Planning Application No: 3/2026/0423

Proposal: Proposed creation of a synthetic turf pitch with fencing, floodlighting, access path, changing block, and the extension and formalisation of the existing car park and ancillary equipment.

Location: Langho Sports and Social Club, Northcote Road, Langho BB6 8BE

Having reviewed the documents submitted Lancashire County Council acting as the highway authority makes the following comments.

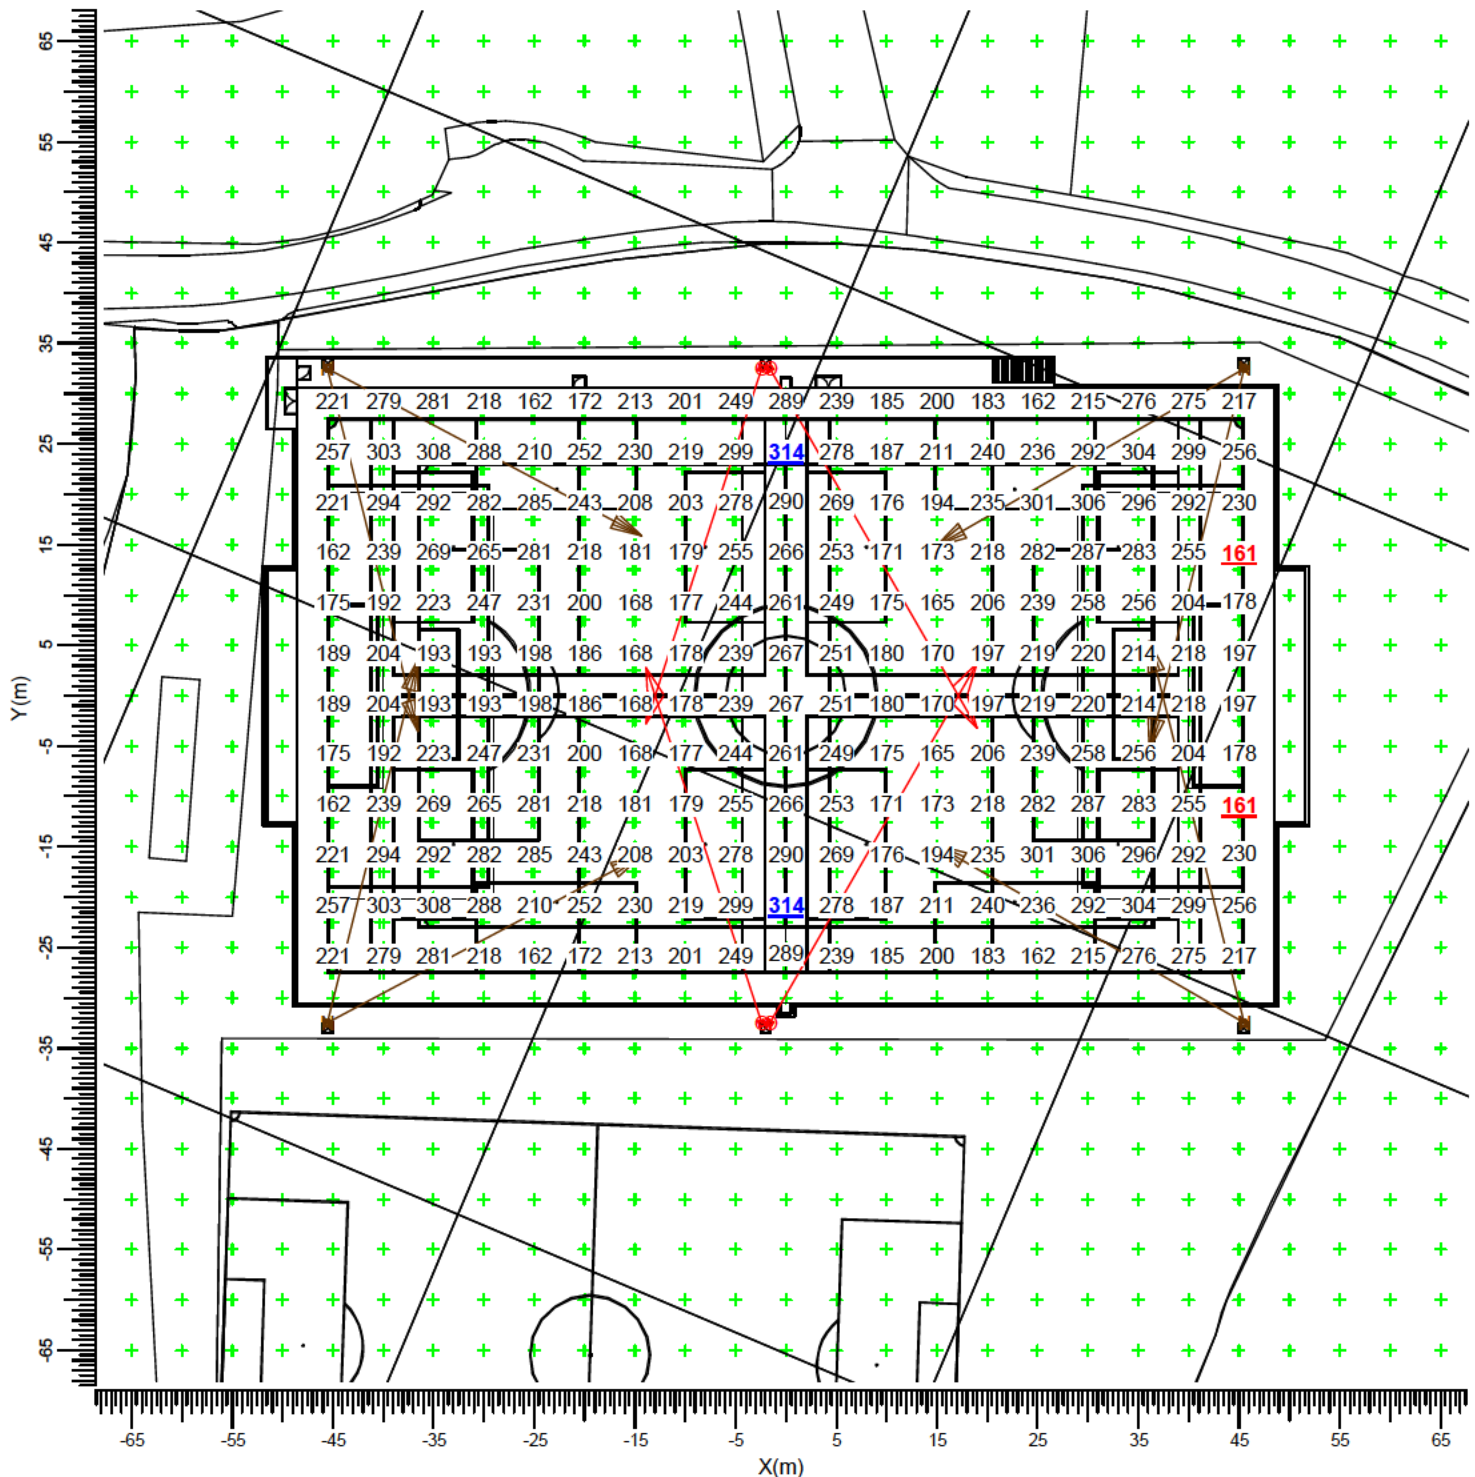
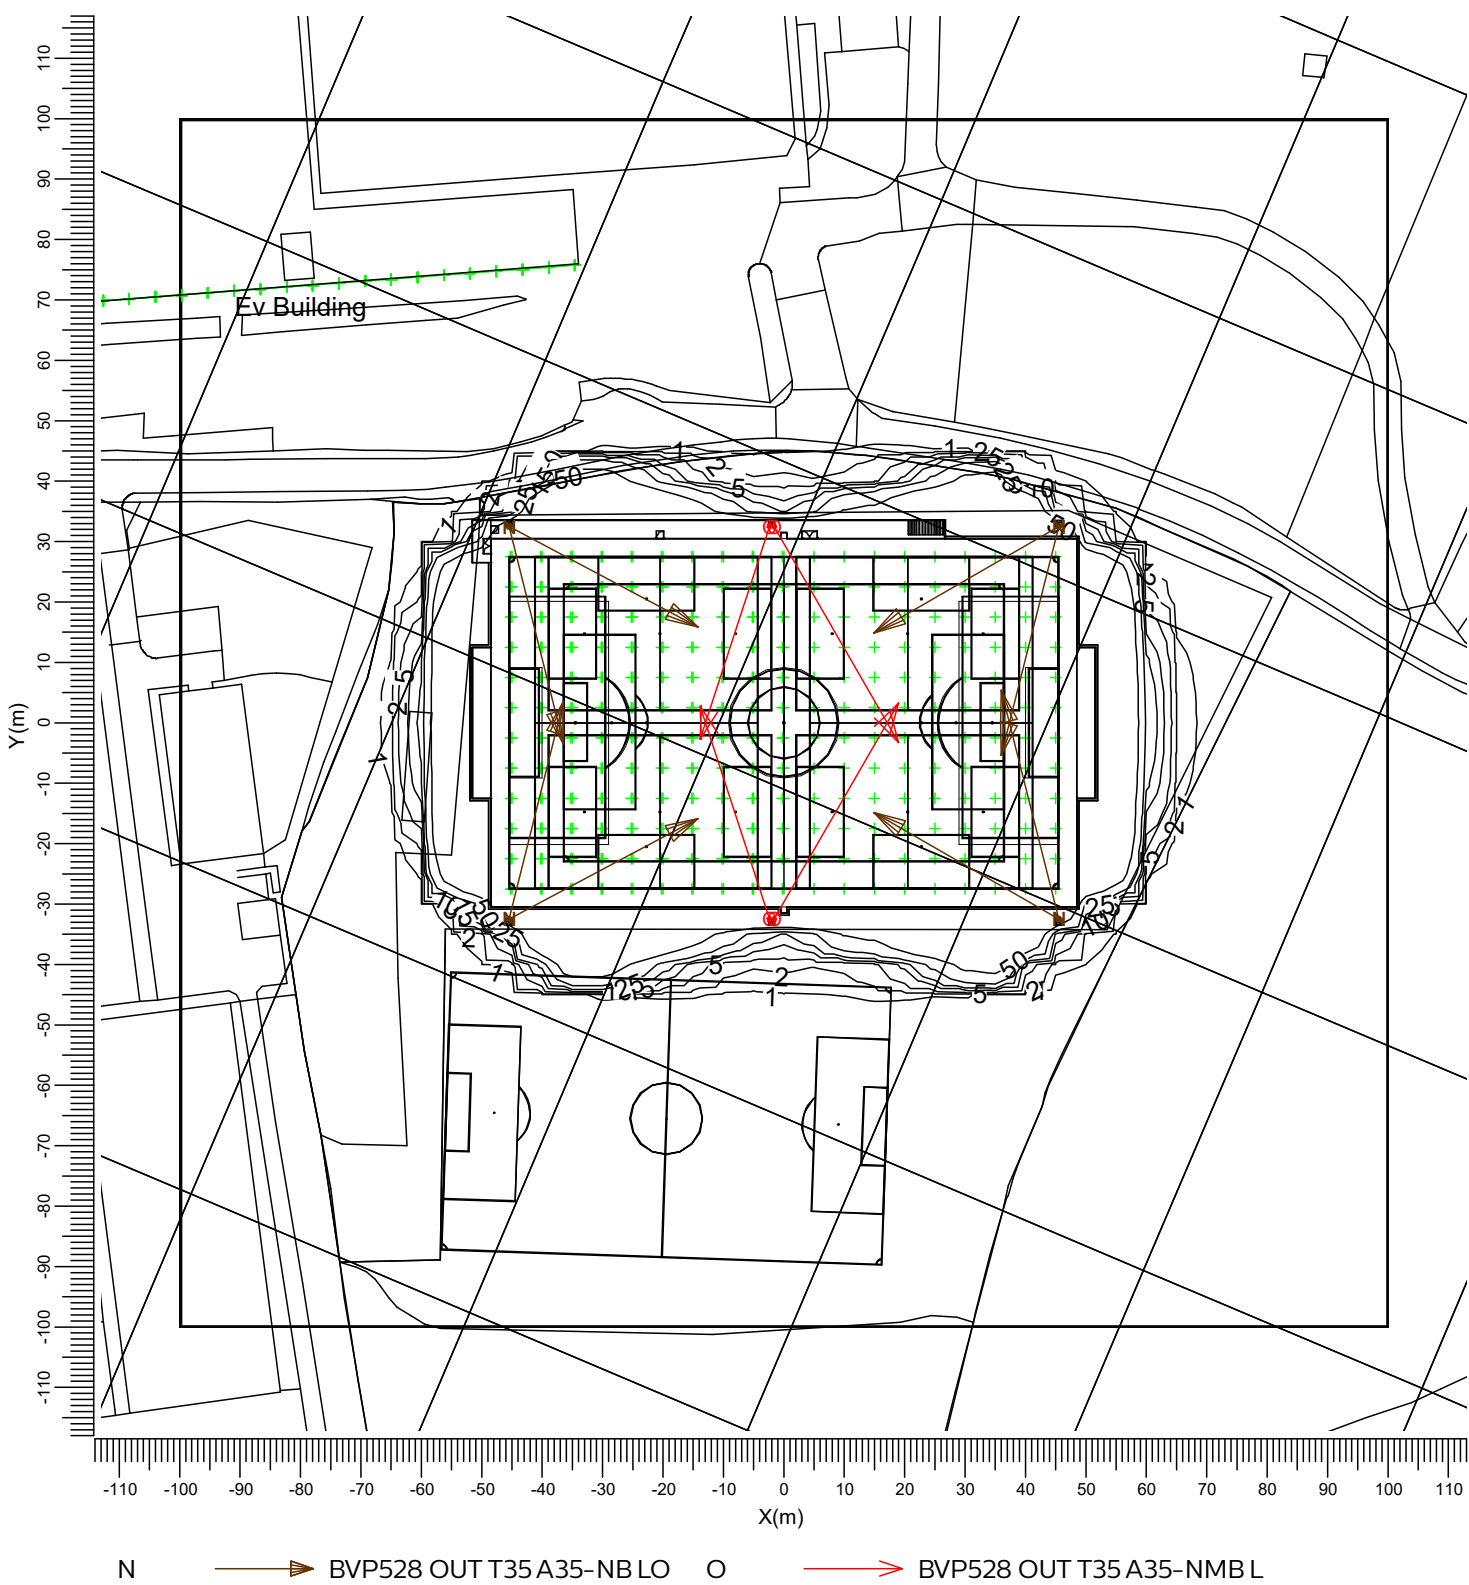
The artificial grass pitch is proposed to be floodlit to enable evening and winter time use. The flood lights should be designed and located so that any external source of lighting is effectively screened from the view of a driver on the adjoining public highway, or exiting from neighbouring properties. This is to avoid glare, dazzle or distraction to motorists.

5. Any external source of lighting shall be effectively screened from the view of a driver on the adjoining public highway. Reason: To avoid glare, dazzle or distraction to passing motorists.

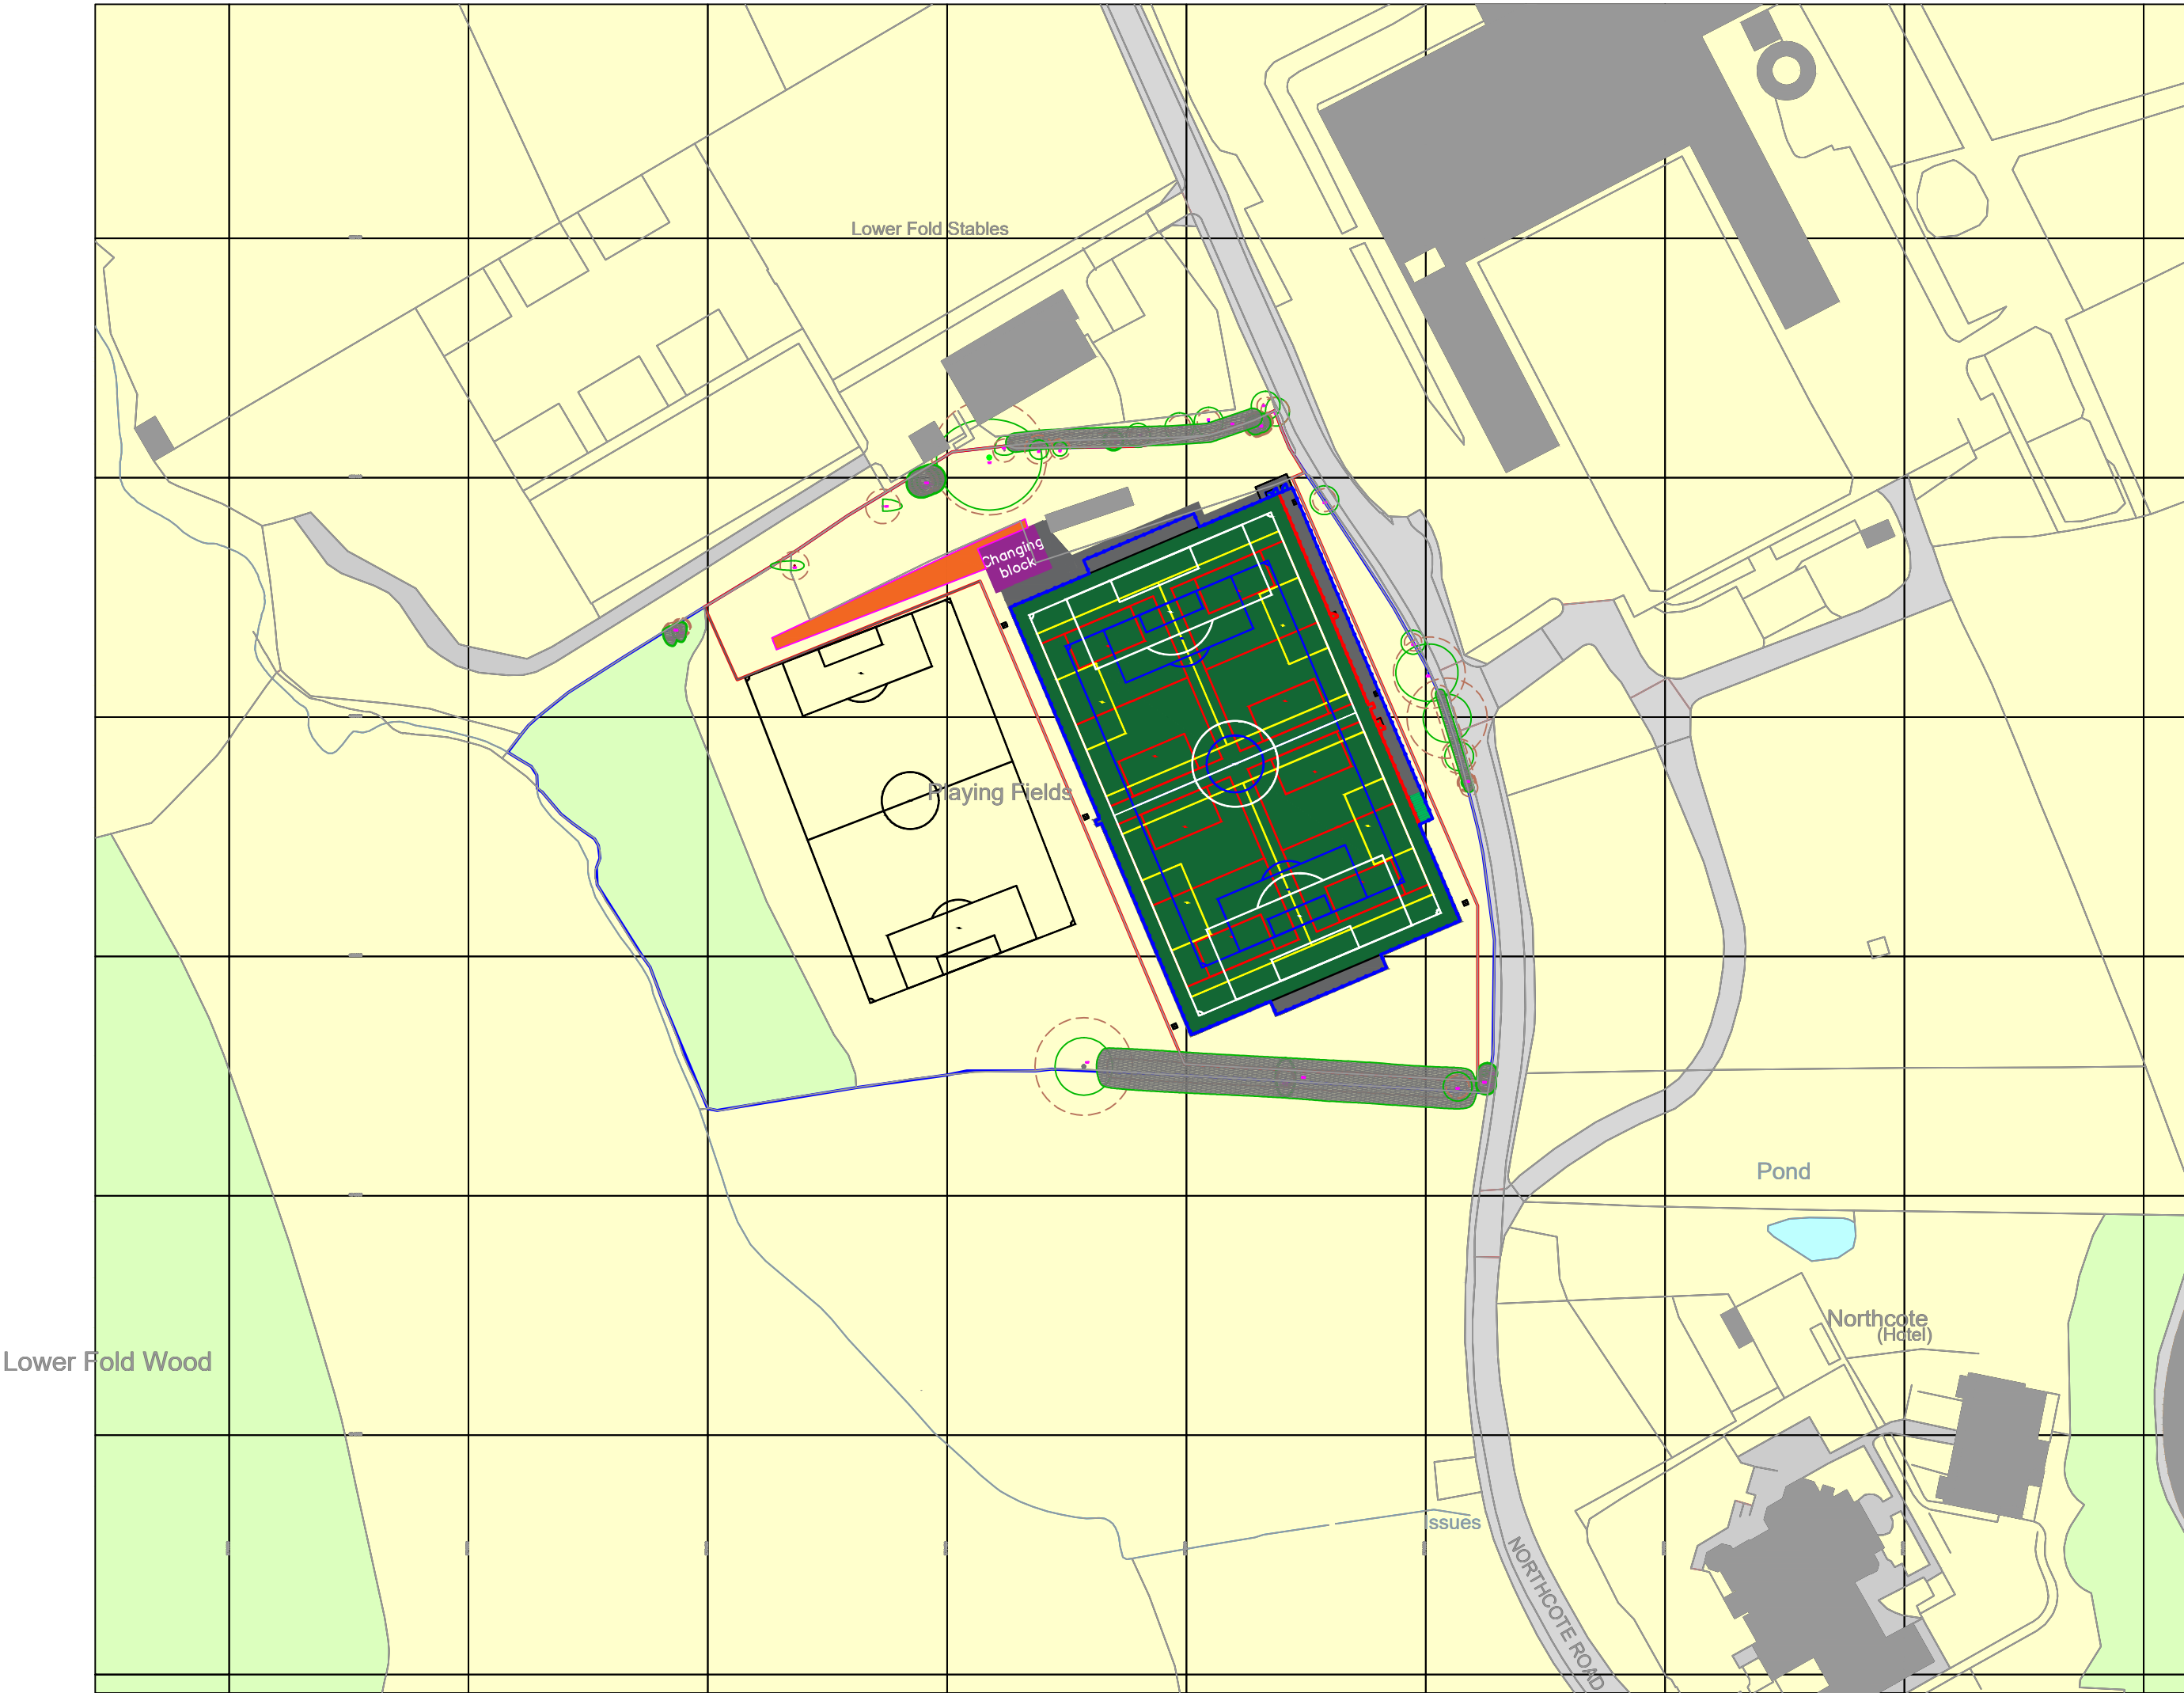
There is an existing vehicular access onto Northcote Road. Minor widening of this access is proposed which would allow two vehicles to pass within the entrance and so prevent vehicles from waiting on Northcote Road, where they could cause an obstruction at peak times.

The existing car parking area is proposed to be extended to the west to create an additional 17 spaces with three disabled parking bays to the east of the existing building, giving an overall total of 54 parking spaces. However bays 35 and 36 only have 5m manoeuvring space and not the minimum 6m recommended for perpendicular bays. The highway authority therefore considers that only 52 parking spaces would be available. Based on the additional parking demands likely to be associated with the new pitch's use the highway authority considers that sufficient on-site parking can still be provided.

An informal turning area is proposed adjacent to bays 34 and 35. This would need to be signed so that it is always kept clear and available for manoeuvring.

3. Notwithstanding the documents submitted a minimum of 52 adequately sized car parking spaces and associated manoeuvring space shall be provided, marked out and signed in accordance with a scheme which shall be submitted to and approved in writing by the Local Planning Authority. The car parking shall be made available in accordance with this scheme prior to first use of the approved development and retained for the lifetime of the development. Reason: In the interest of highway safety to ensure that adequate levels of parking and manoeuvring are provided on the site.
